**Consultation Response from KC,
Lead Local Flood Authority**

2024/92281 Land adj, 17, Whitehall Road West, Birkenshaw, BD11 2LS

Erection of 23 dwellings

Date Responded: 27th May 2025

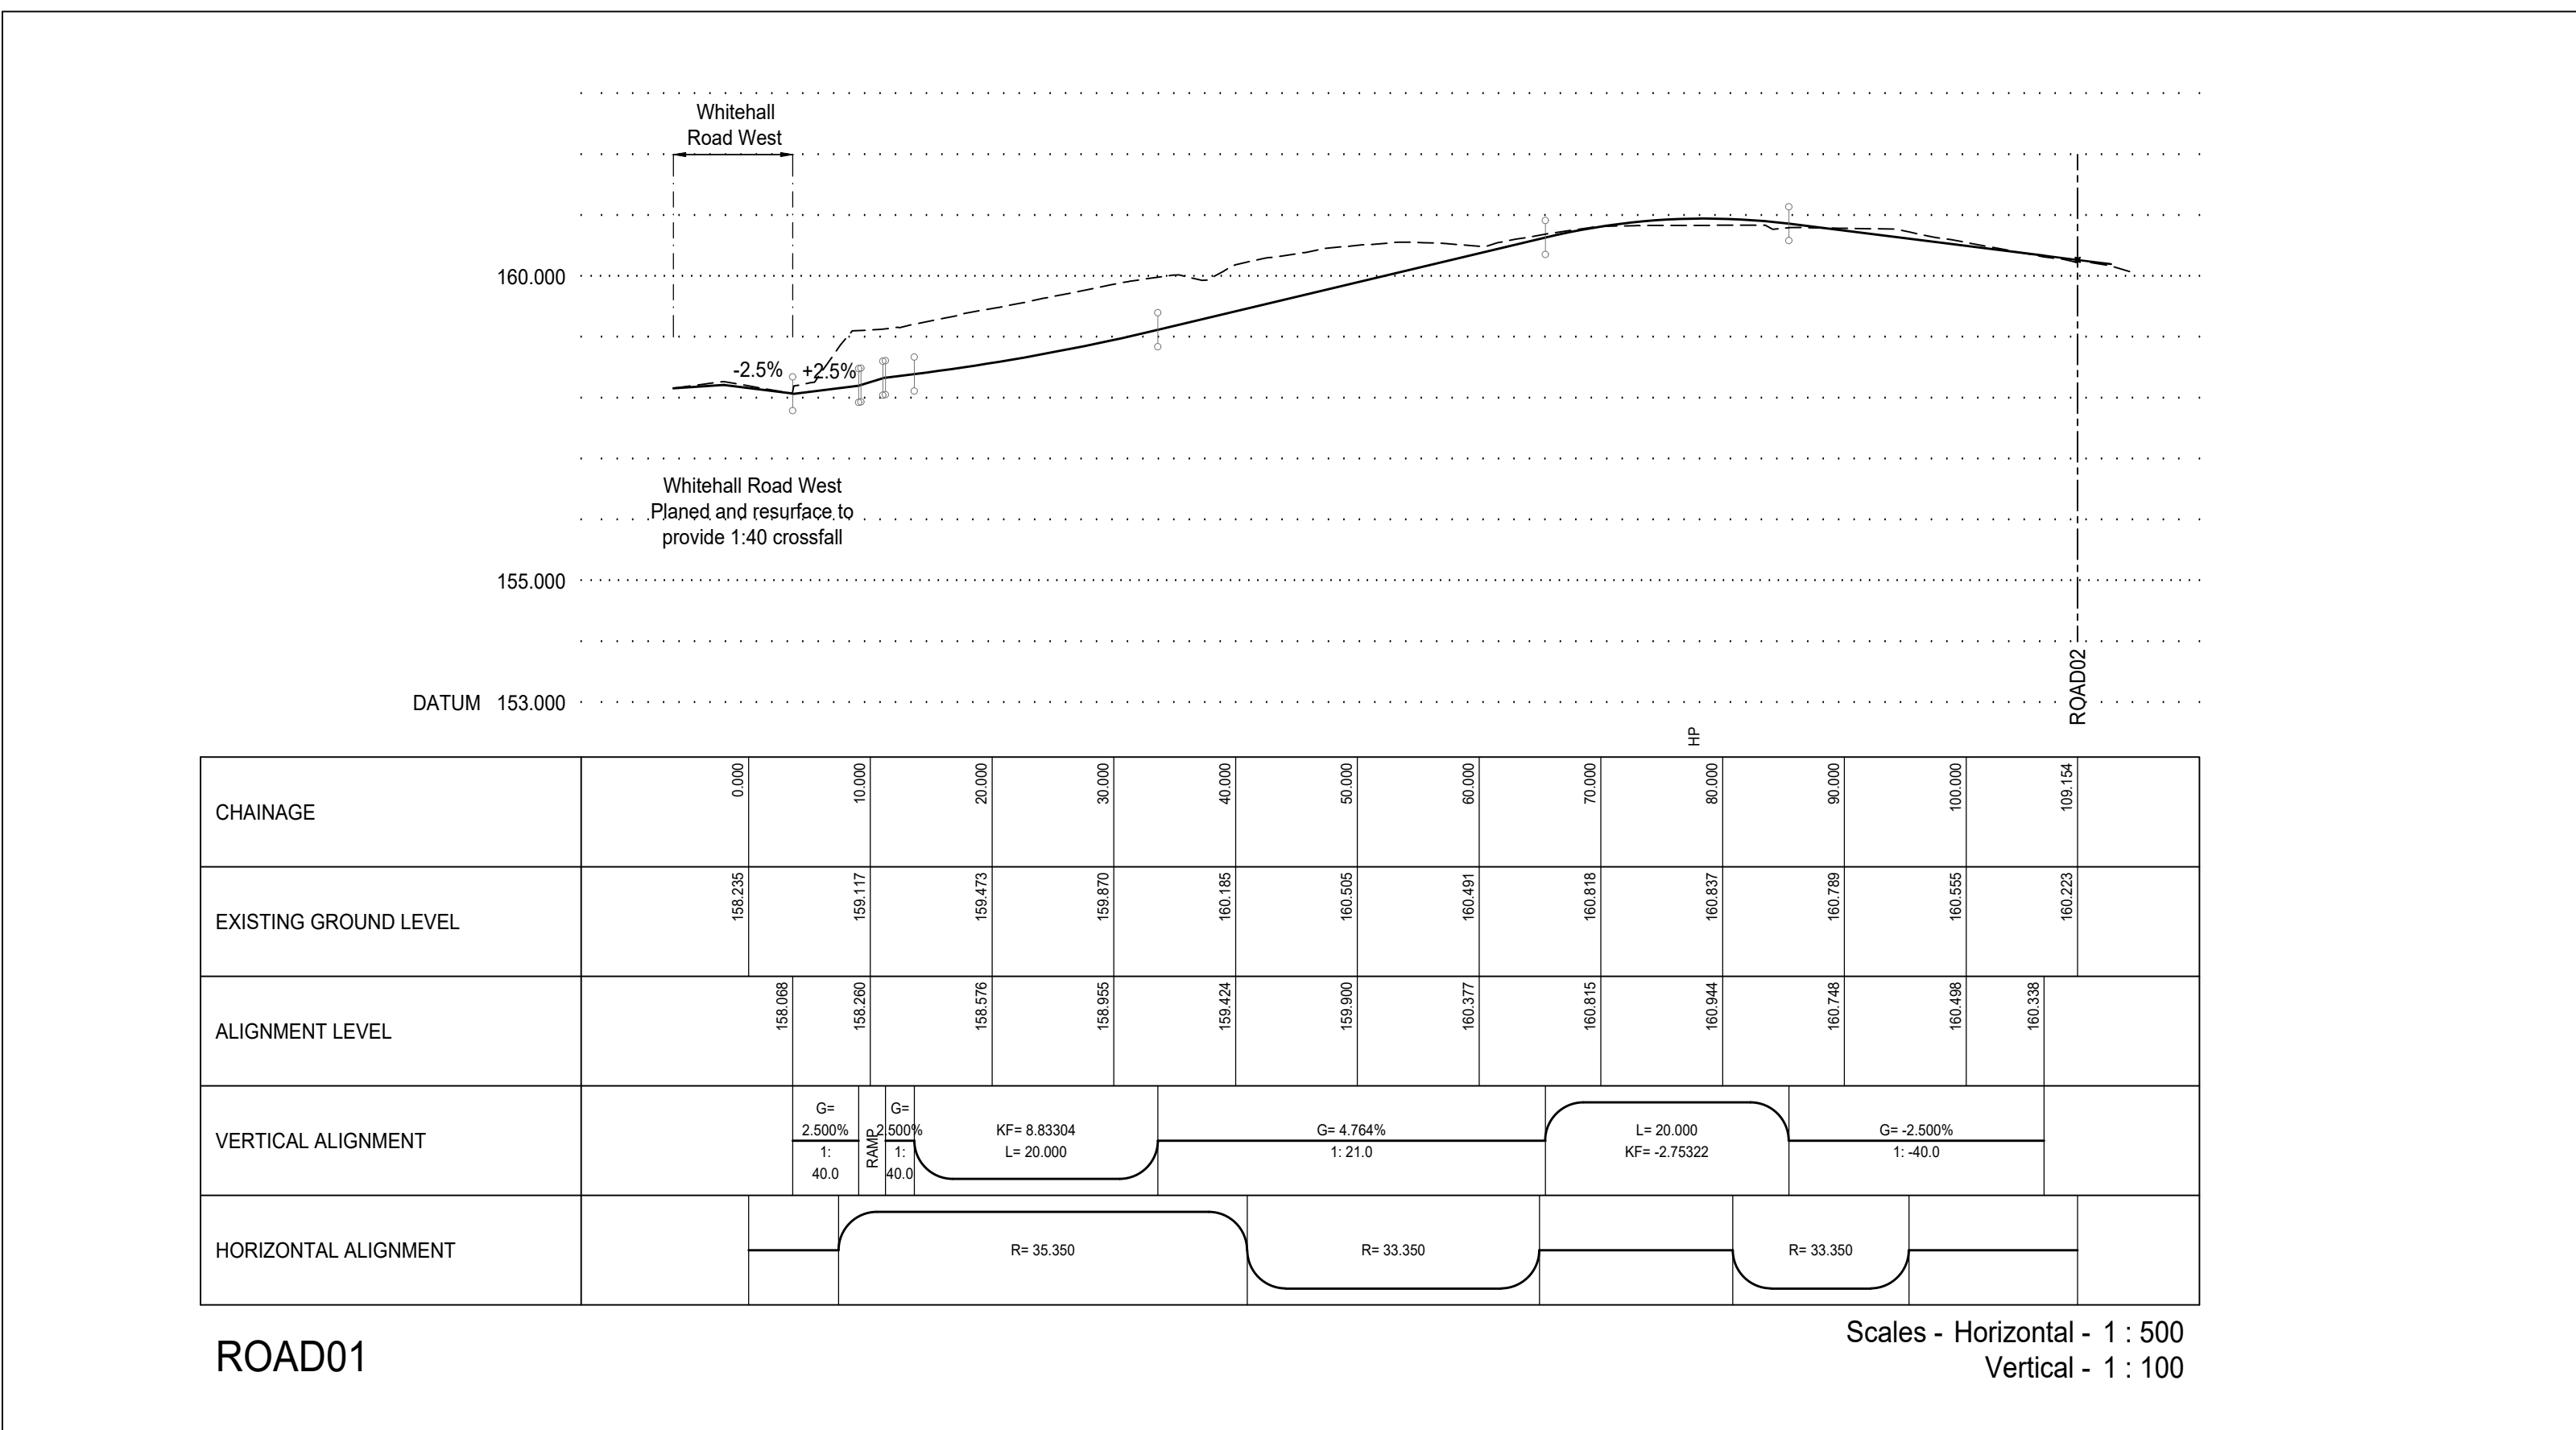
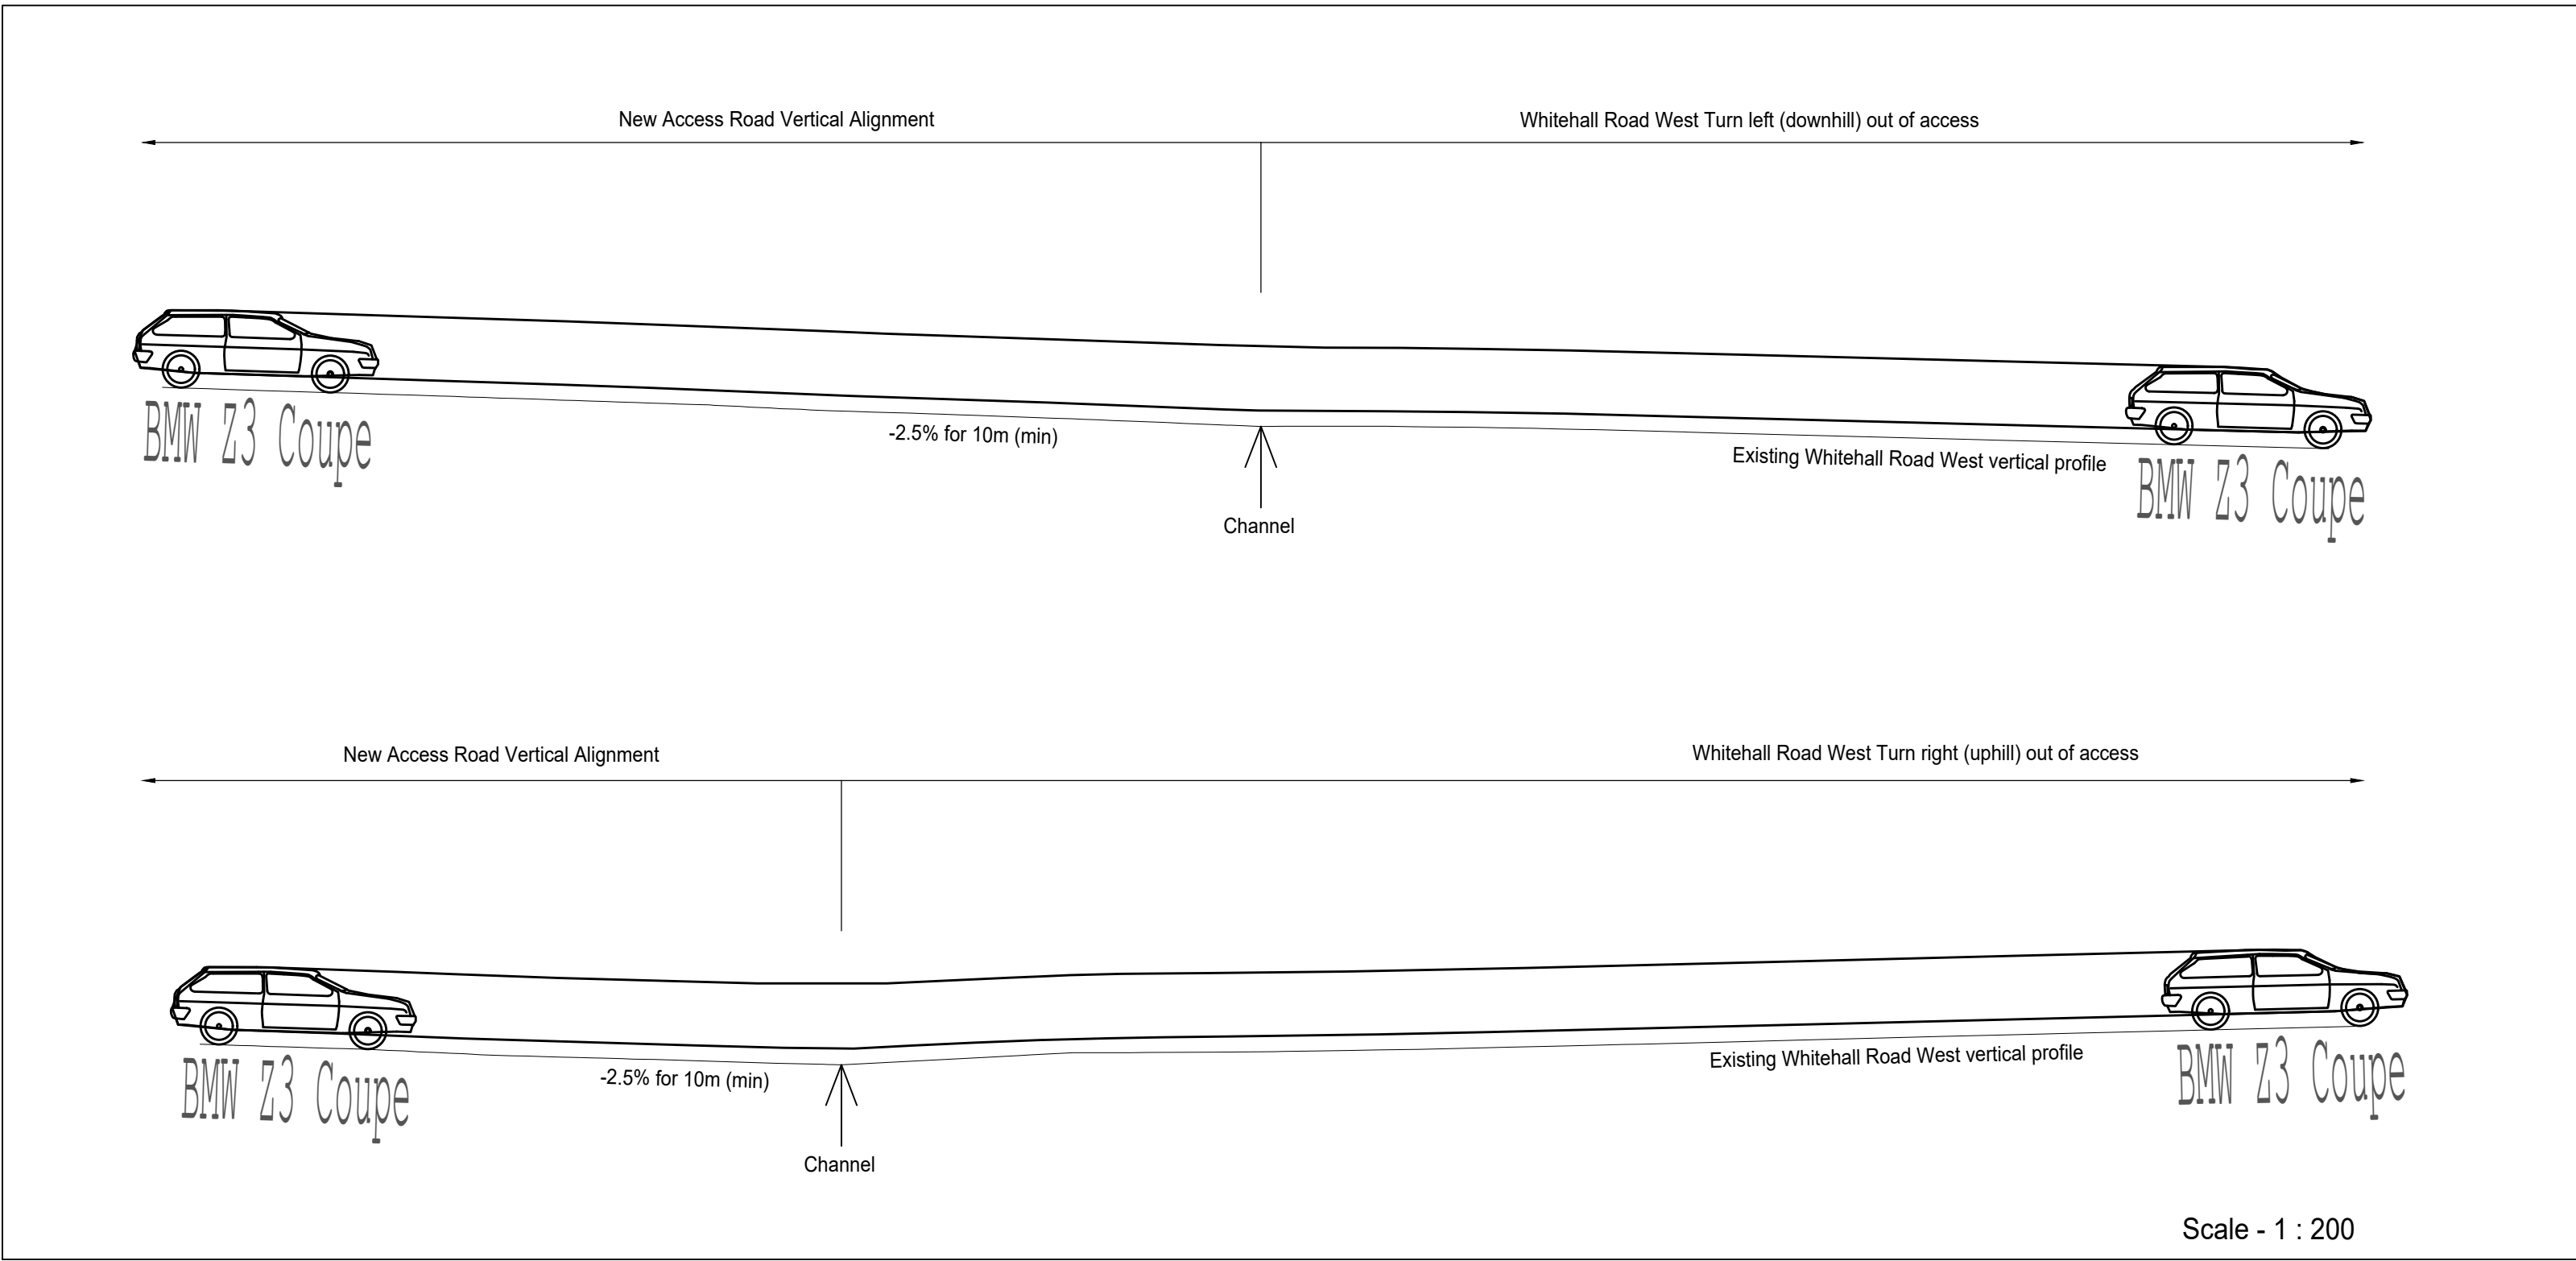
Further to our comments of 11th April, flooding will still occur from the gulleys near the tank. A cross sectional drawing and plan of the tank is still required (showing length, width and depth), as is a coloured impermeable area diagram. All previously requested.

Title: **General Arrangement 1 of 3 StormTank MPS 32.812 x 7.6 x 1.3 / 0.9 m**

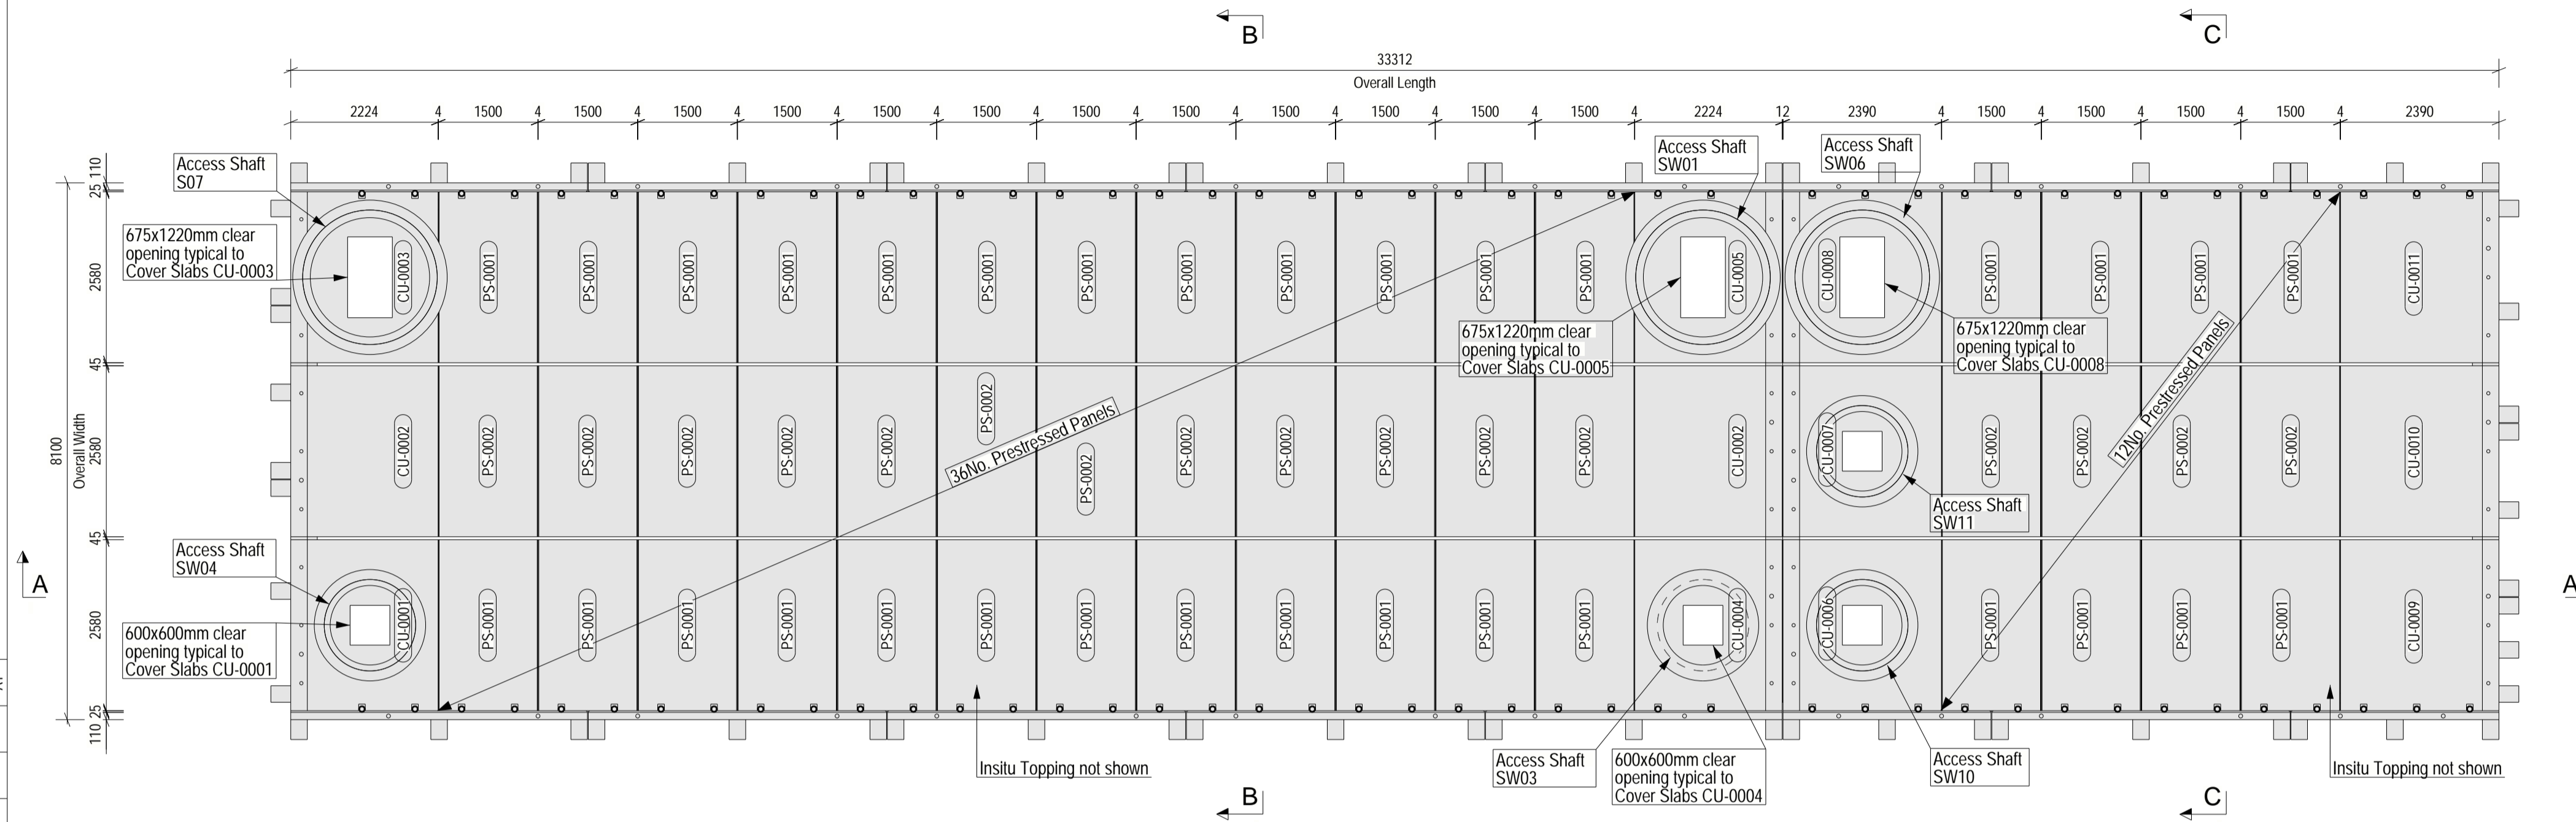
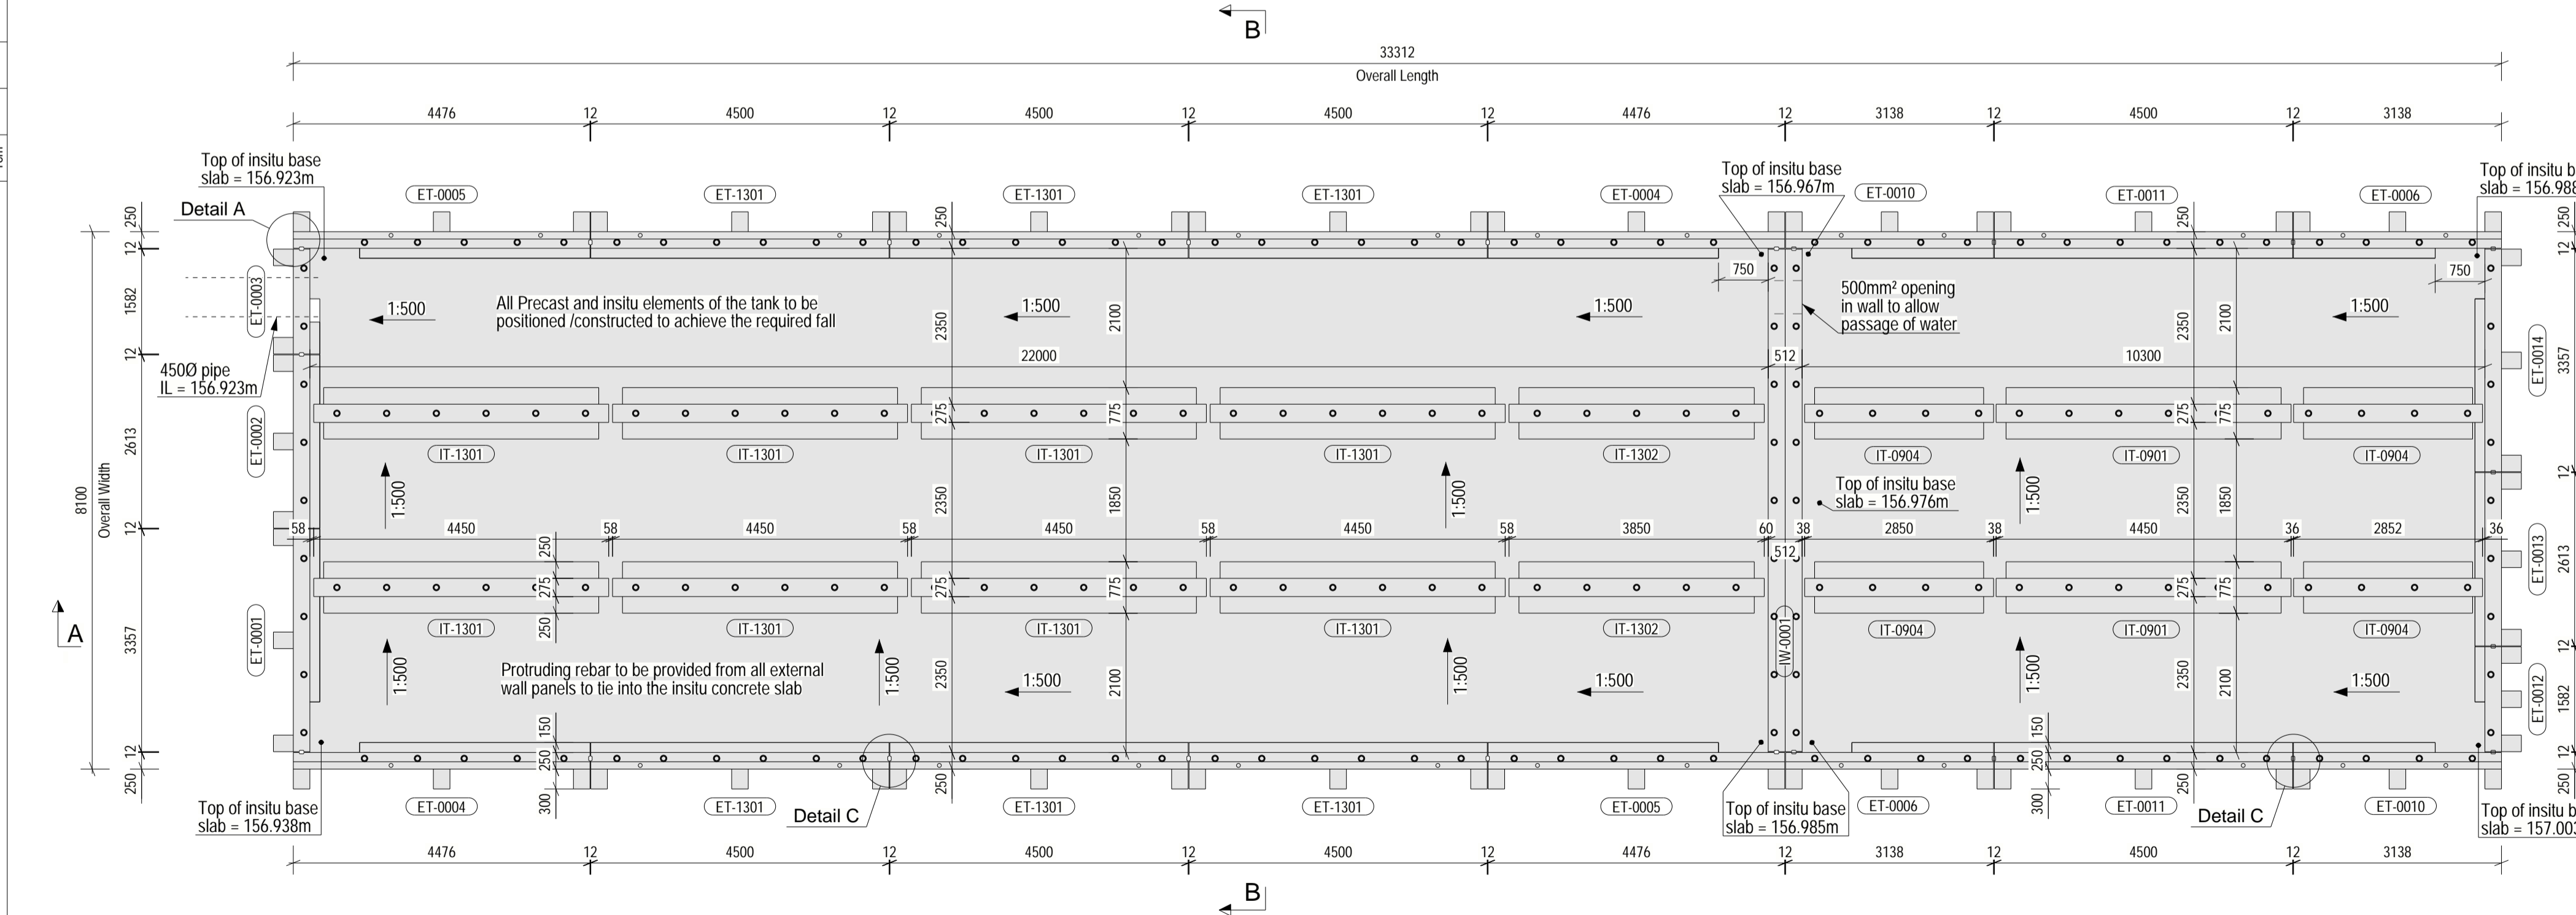
Please note that when entering depths again area on flow simulation models, please make sure that the depth at which there is no volume, i.e. immediately above the tank is shown as 1mm greater than the soffit level of the tank.
